PLANNING CONSULTATION RESPONSE

Application No	2026/0318
Proposal	2026 0318 Erection of Hoardings and Dismantling and rebuilding of a Section of the Western Gatehouse Wall Monk Bretton Priory Abbey Lane Lundwood
Address	Monk Bretton Priory Abbey Lane Lundwood
Date of Consultation Reply	150526
Consultee	Tony Wiles Senior Conservation Officer

Section of the West Wall of the Gatehouse 1:100

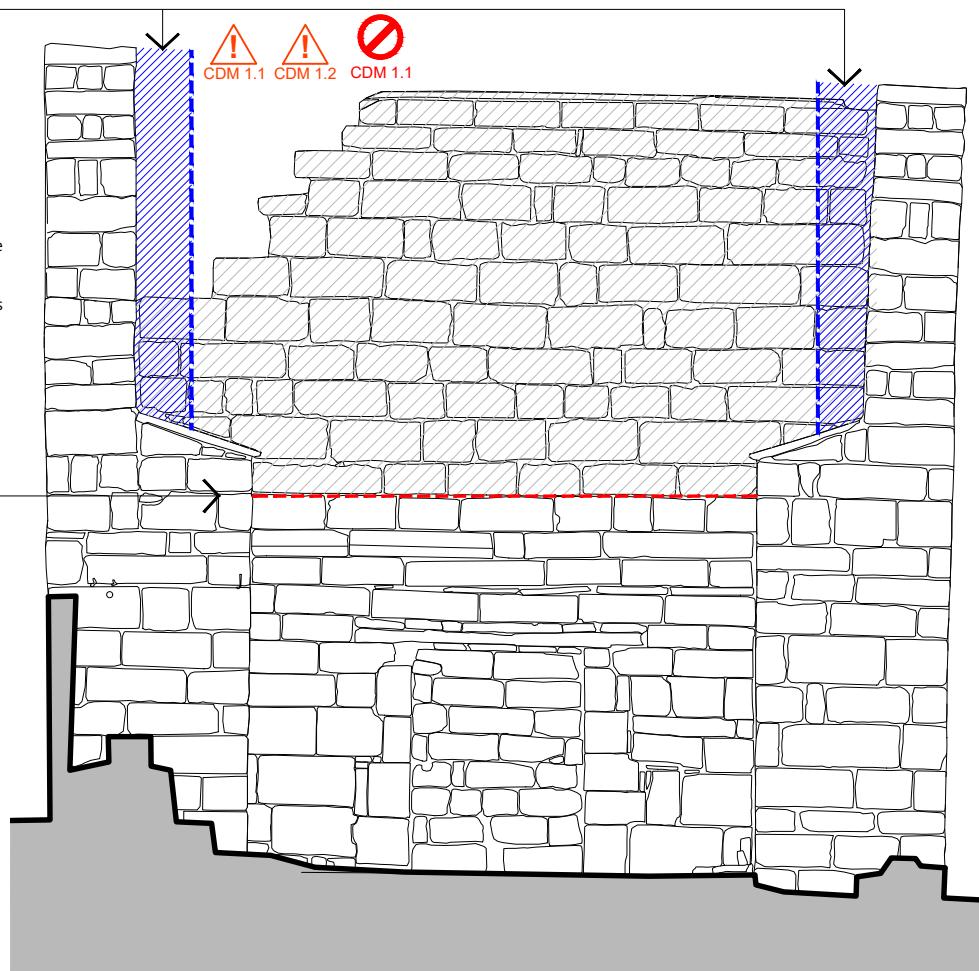
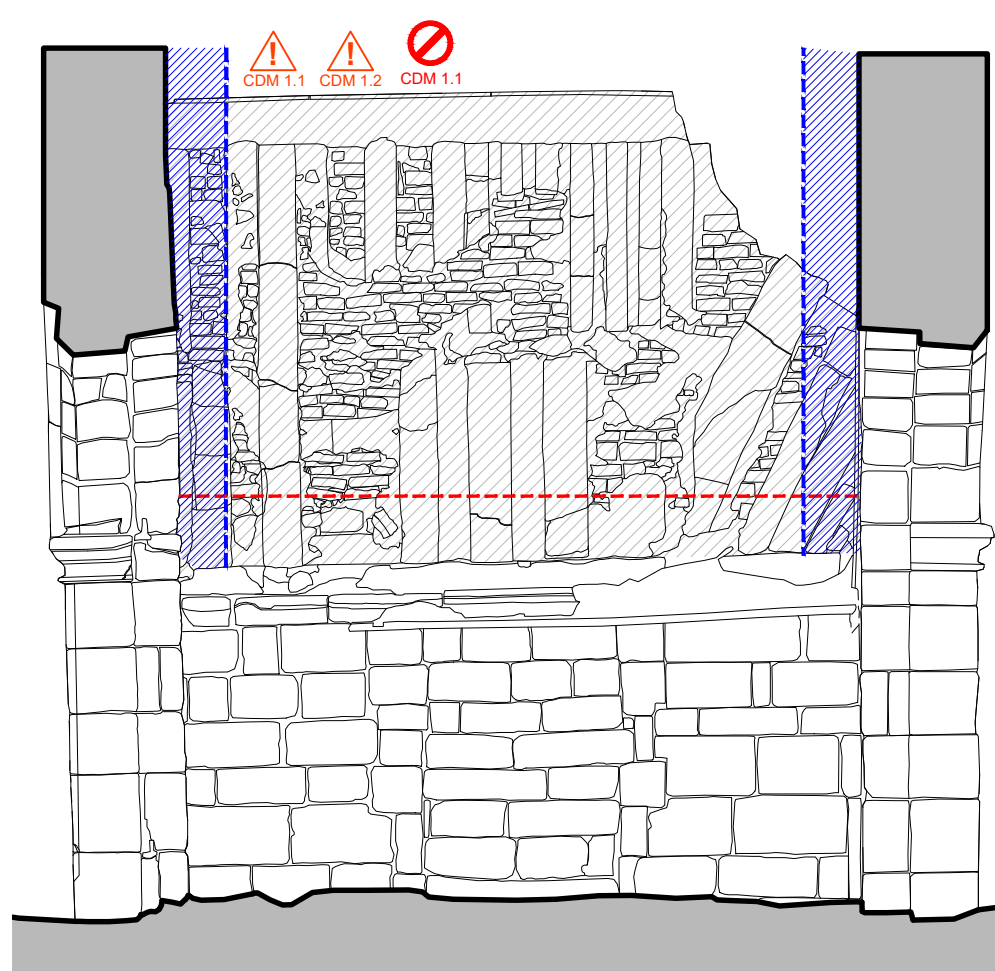
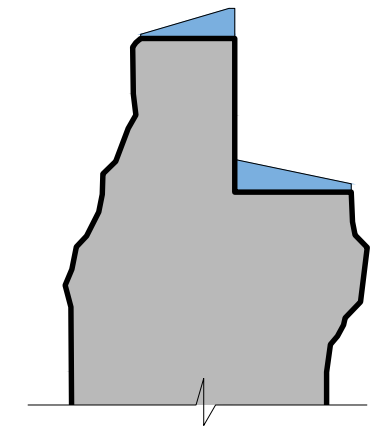
Following the dismantling described above, a sacrificial mortar cap in lime will be applied to the exposed stonework on the western and eastern wall tops. Two brick piers utilising re-claimed brick will be erected to stabilise and buttress the existing stone (buttresses). These will provide adequate restraint whilst the upper gatehouse wall remains dismantled. Crooks Architecture plan BMBP P/02 Rev. A shows the proposed works. Due to budgetary constraints the works is phased over three financial years. The initial planning and dismantling taking place during 25/26 which will involve the erection of hoardings and the brick piers. This will be followed by the implementation phase during 26-28 that will include the rebuilding of the western wall. This phase will also include an interpretation panel on the eastern (internal) elevation that will recreate the impression of the timber studding that is currently preserved in the cement render. The intention is to coordinate the works for the dismantling and brick pier works and the rebuilding of the wall with me (BMBC Senior Conservation Officer) to agree full details of the rebuilding and specifications etc. To that end I've suggested a condition below that could either be worded to require agreement in writing (discharge of conditions) or could simply be proscriptive. In fact, two conditions might be needed to cover the initial phase of works (detail of the dismantling and piers) and the second phase of works (details for the rebuilding and interpretation – discharged a later date). This will require agreement with the applicant.

- The sacrificial mortar cap to be installed above the chamfered course to the head of the wall as part of the Phase 1 works hereby permitted shall use a pure loose lime putty in accordance with the details set out by paragraph MOR.8 in the submitted Specifications document produced by Crooks Architecture.

- The brick strengthening piers to be erected as part of the Phase 1 works hereby permitted shall be constructed of reclaimed brick and shall be erected using a pure hot lime mortar mix in accordance with the details set out by paragraphs MOR.1 to MOR.15 in the submitted Specifications document produced by Crooks Architecture. Once erected, the piers shall be pointed in a similar hot lime mix.
